Address: 22, Warehouse Hill Road, Huddersfield, hd7 6ad

Application number: 2026/91456	
What is the application for?:	Formation of patio and steps
Address of the site or building:	38, Grange Avenue, Marsden, Huddersfield, HD7 6AQ
Postcode:	HD7 6NE

Drawing number
02 A.

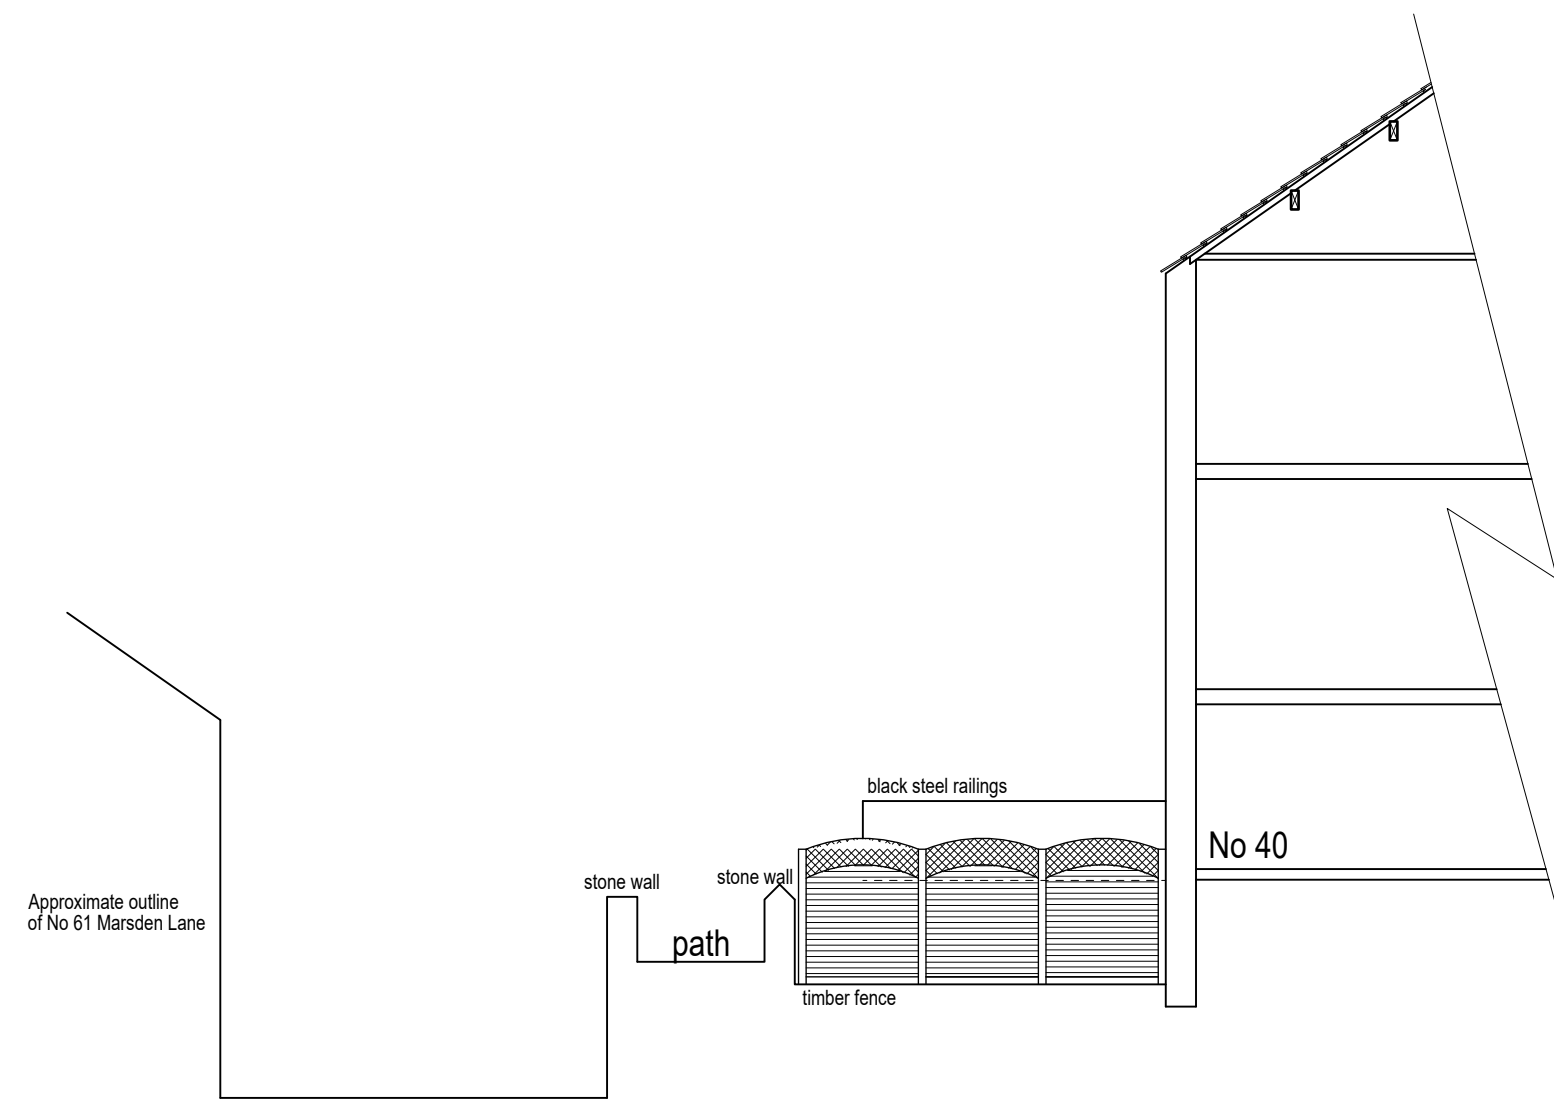
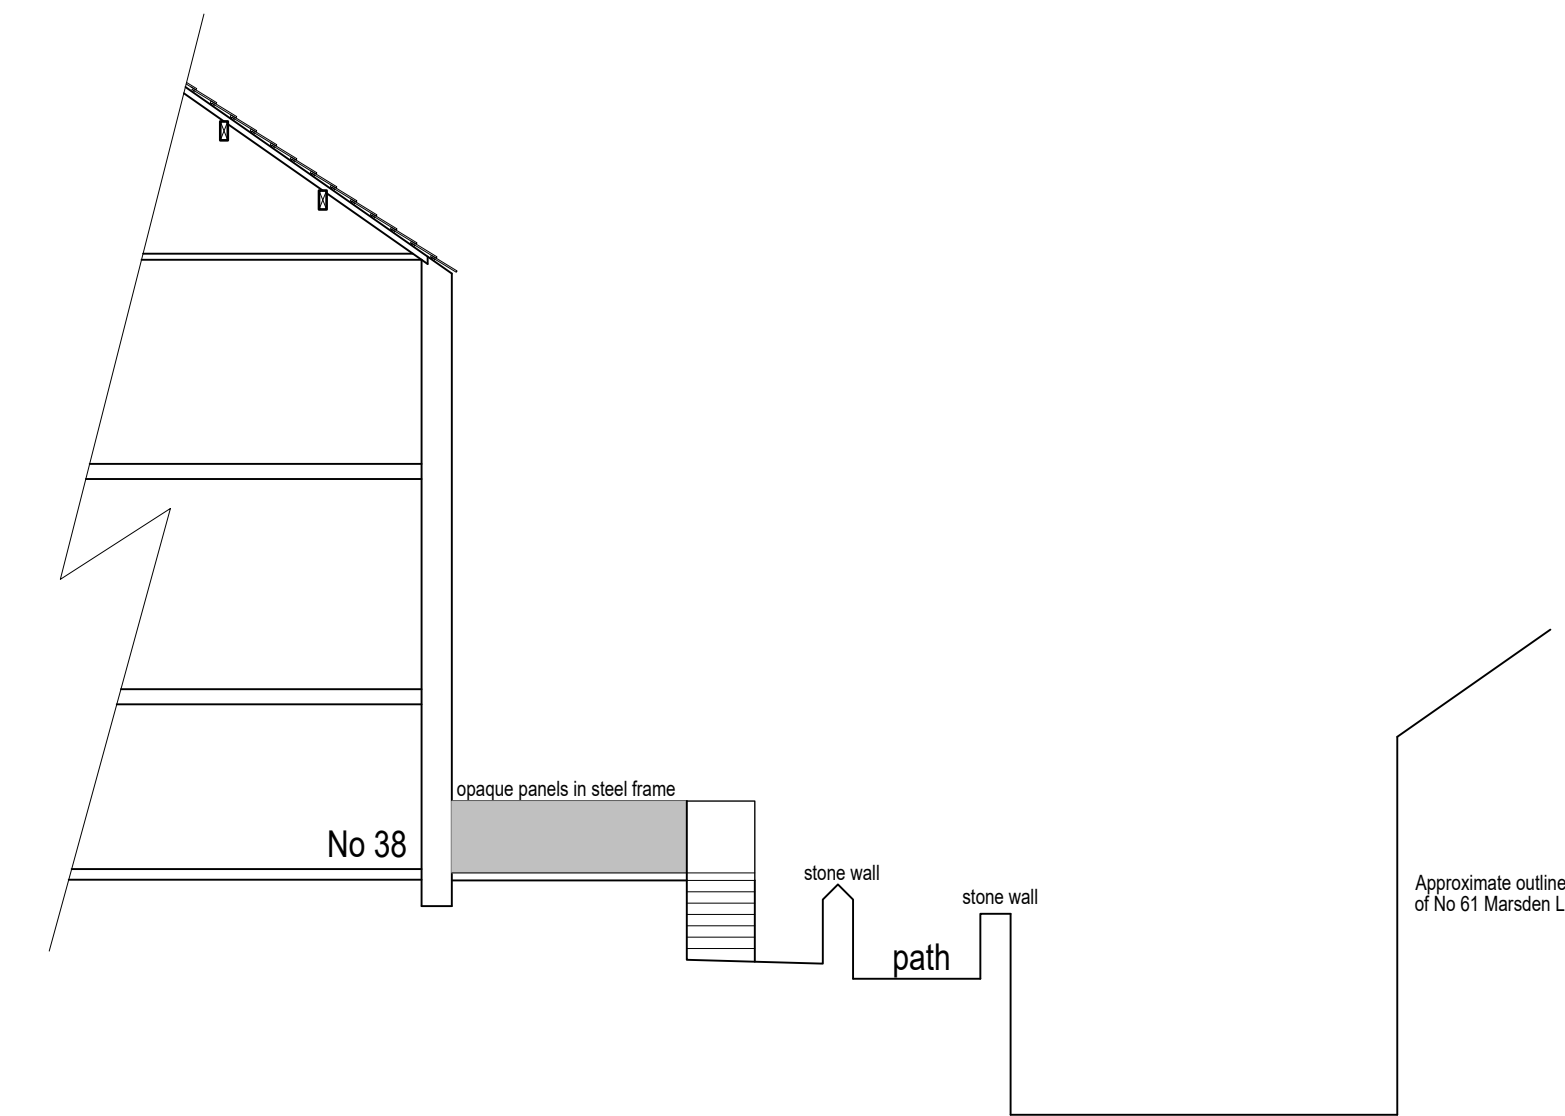
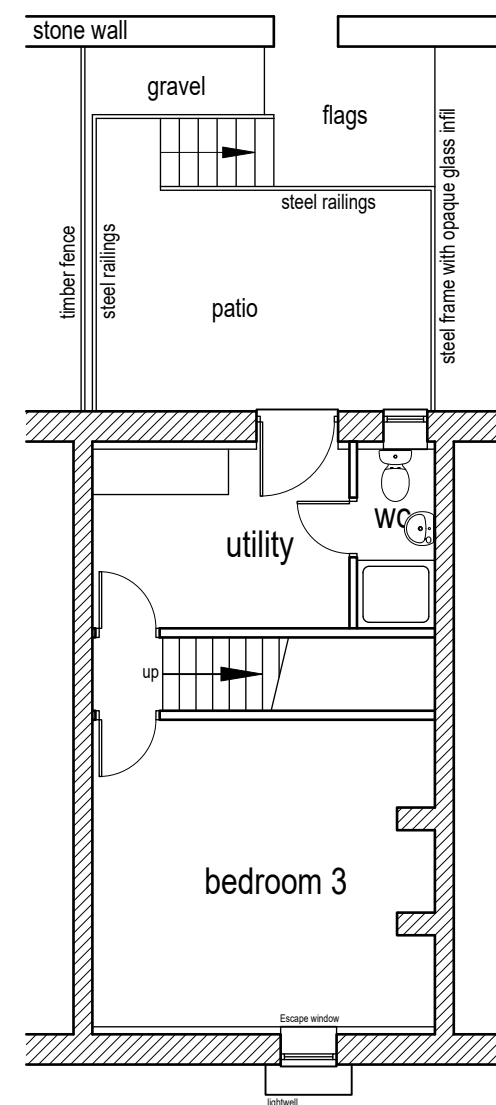
Type of comment: An objection	
Do you wish your comments to be published on the website anonymously?	No
I believe this structure dominates the surrounding gardens, removing neighbors privacy and blocking light from adjacent gardens. There has been a substantial loss of vegetation as the structure now is all concrete or stone, this will affect local wildlife. Due to the materials used there is now no ground water soakaways and i fear this may lead to flooding in other close areas.
